Restaurant at 8100 Wyoming Boulevard

Administrative Amendment Request

Project #PR- 2021-005547

Transportation Development Comments:

**SITE PLAN**  
 1" = 20'

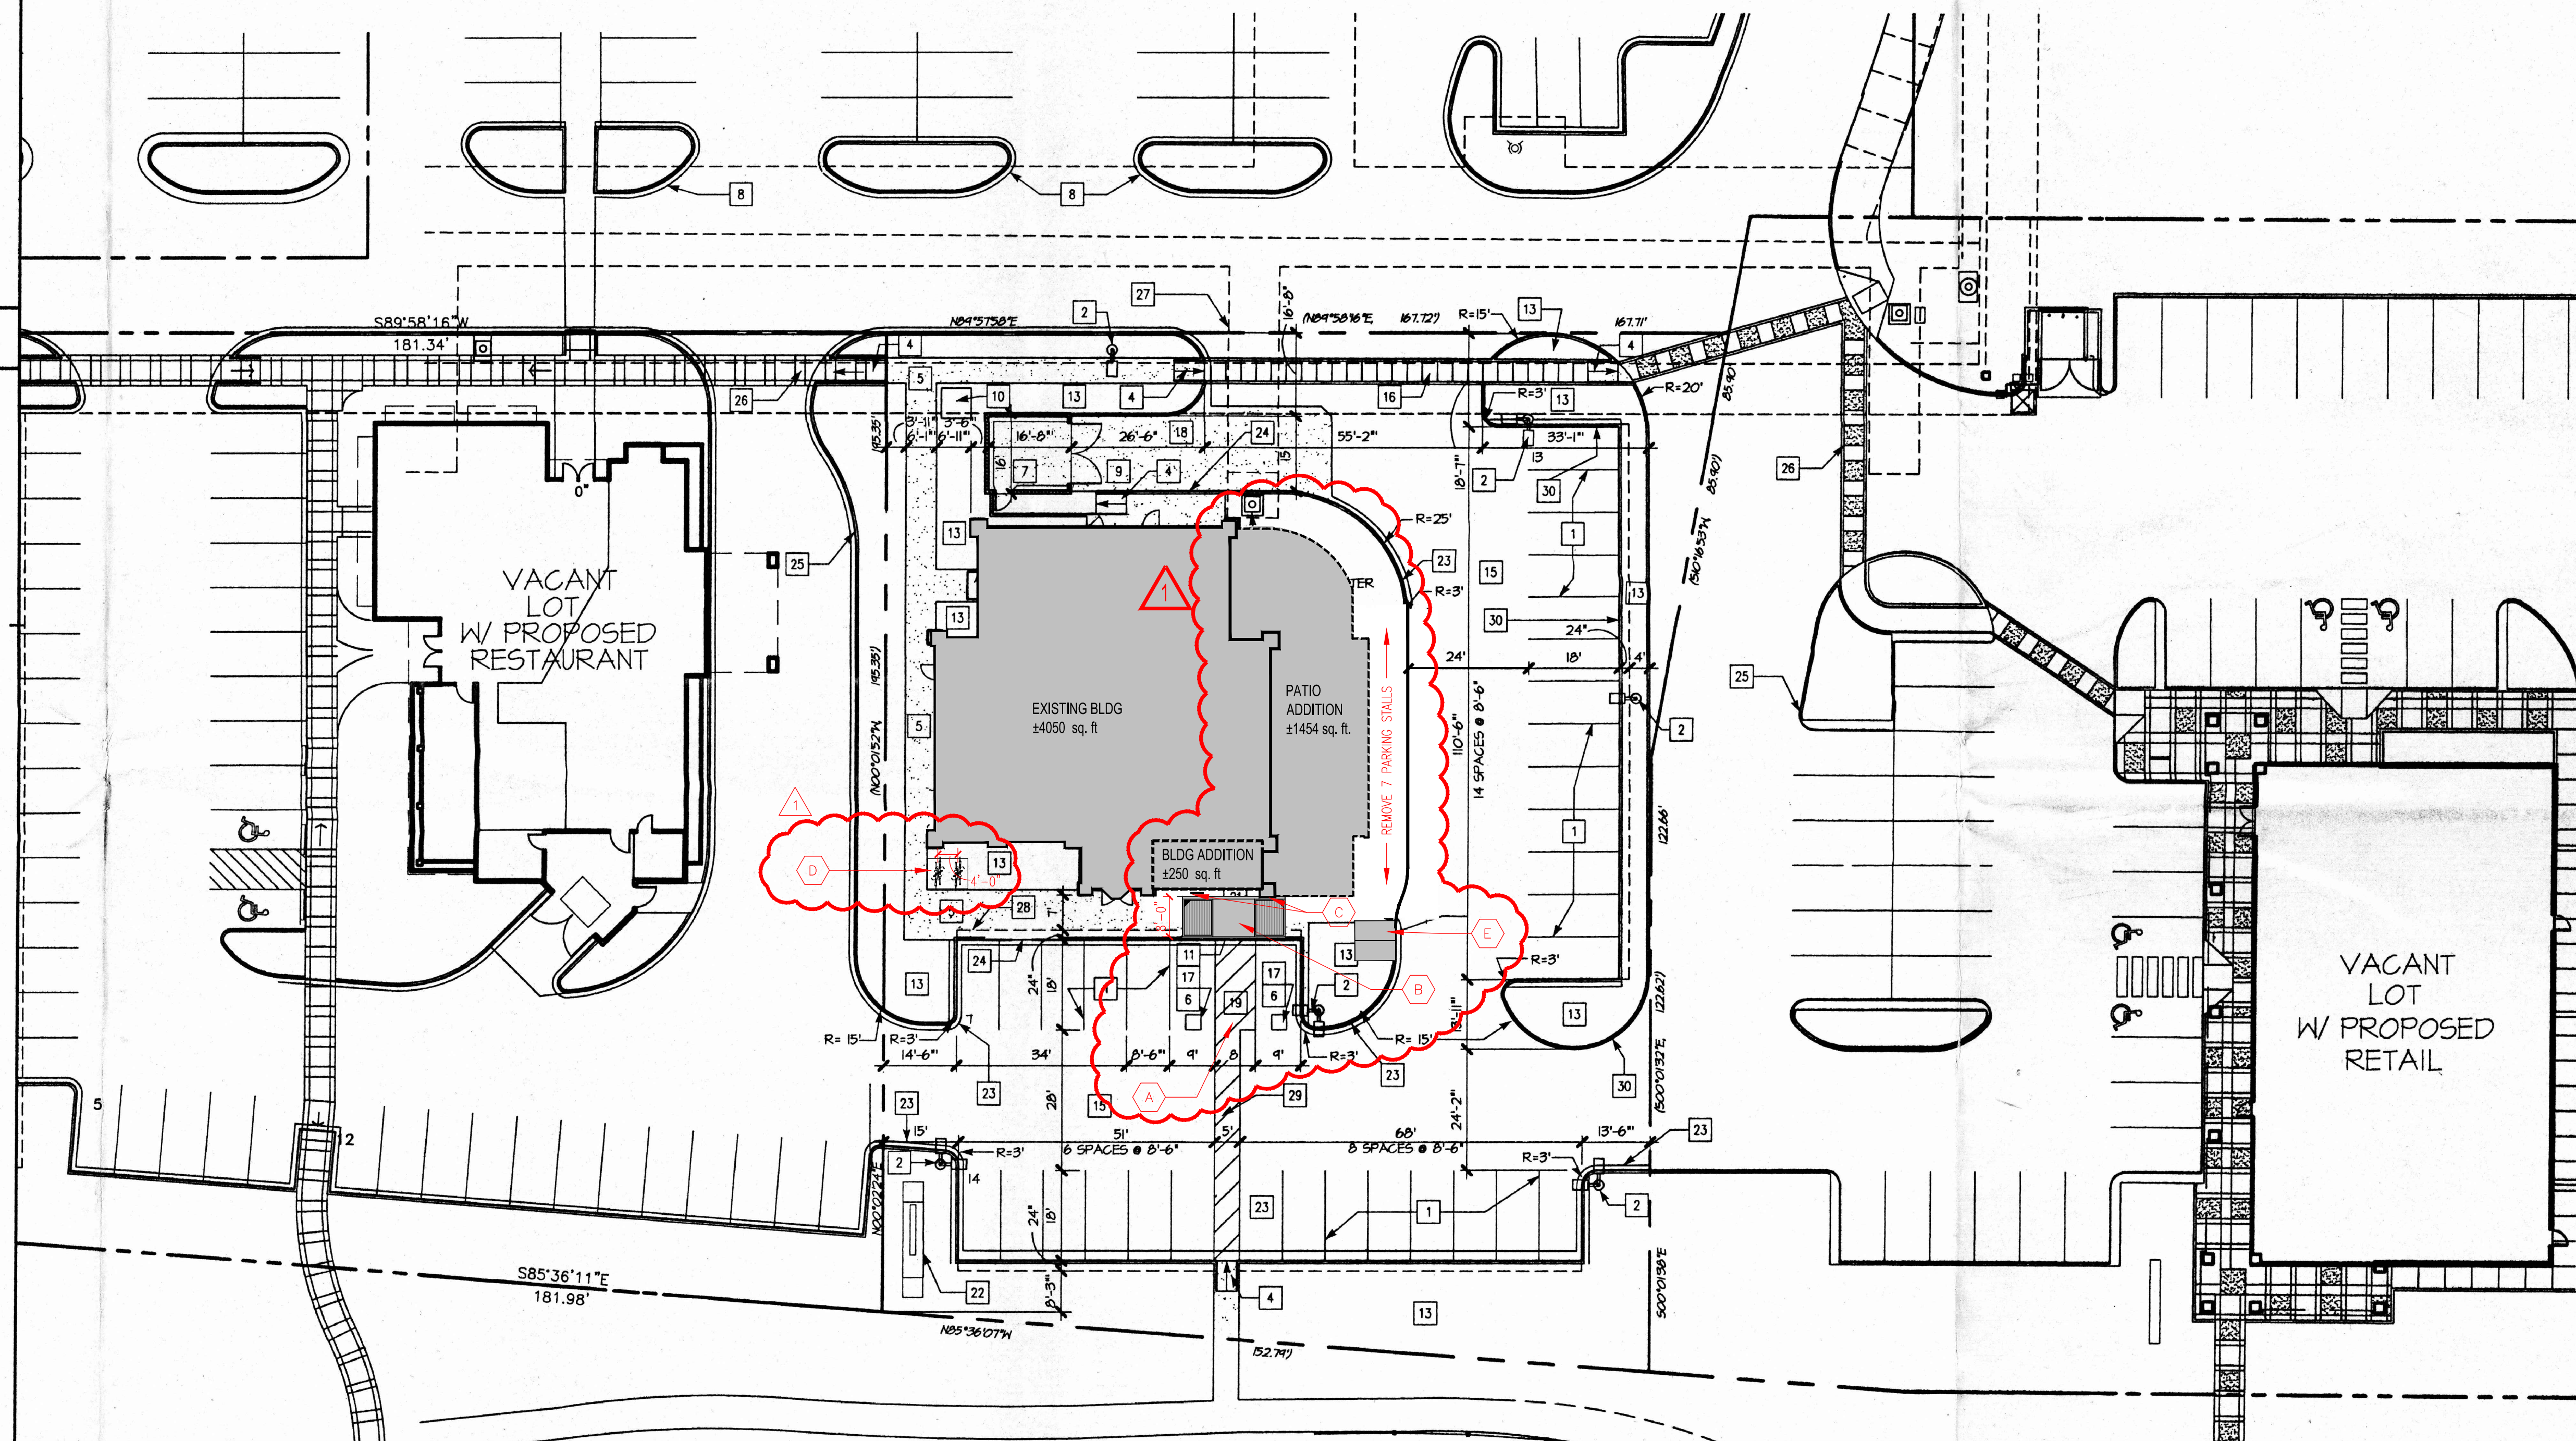
1. For parking calculations, also account for the outdoor seating per IDO requirements. Provide Shared Parking Agreement as needed, and adjust ADA parking as needed.

2. Due to the 250 square foot building addition, verify adequate ADA access from the existing van accessible aisle. Provide information on existing curb ramp, and provide a dimension for the turning space behind the curb ramp to ensure at least a 4-foot wide turning space.

3. Provide a bike rack and motorcycle parking per new IDO requirements. Add details as necessary for the rack and signage. Label "MC" at back of the parking space for the motorcycle parking.

4. The ADA access aisle shall have the words "**NO PARKING**" in capital letters, each of which shall be at least one foot high and at least two inches wide, placed at the rear of the parking space so as to be close to where an adjacent vehicle's rear tire would be placed. (66-1-4.1.B NMSA 1978)

5. The ADA accessible parking sign must have the required language per 66-7-352.4C NMSA 1978 "**Violators Are Subject to a Fine and/or Towing.**" Add this detail.
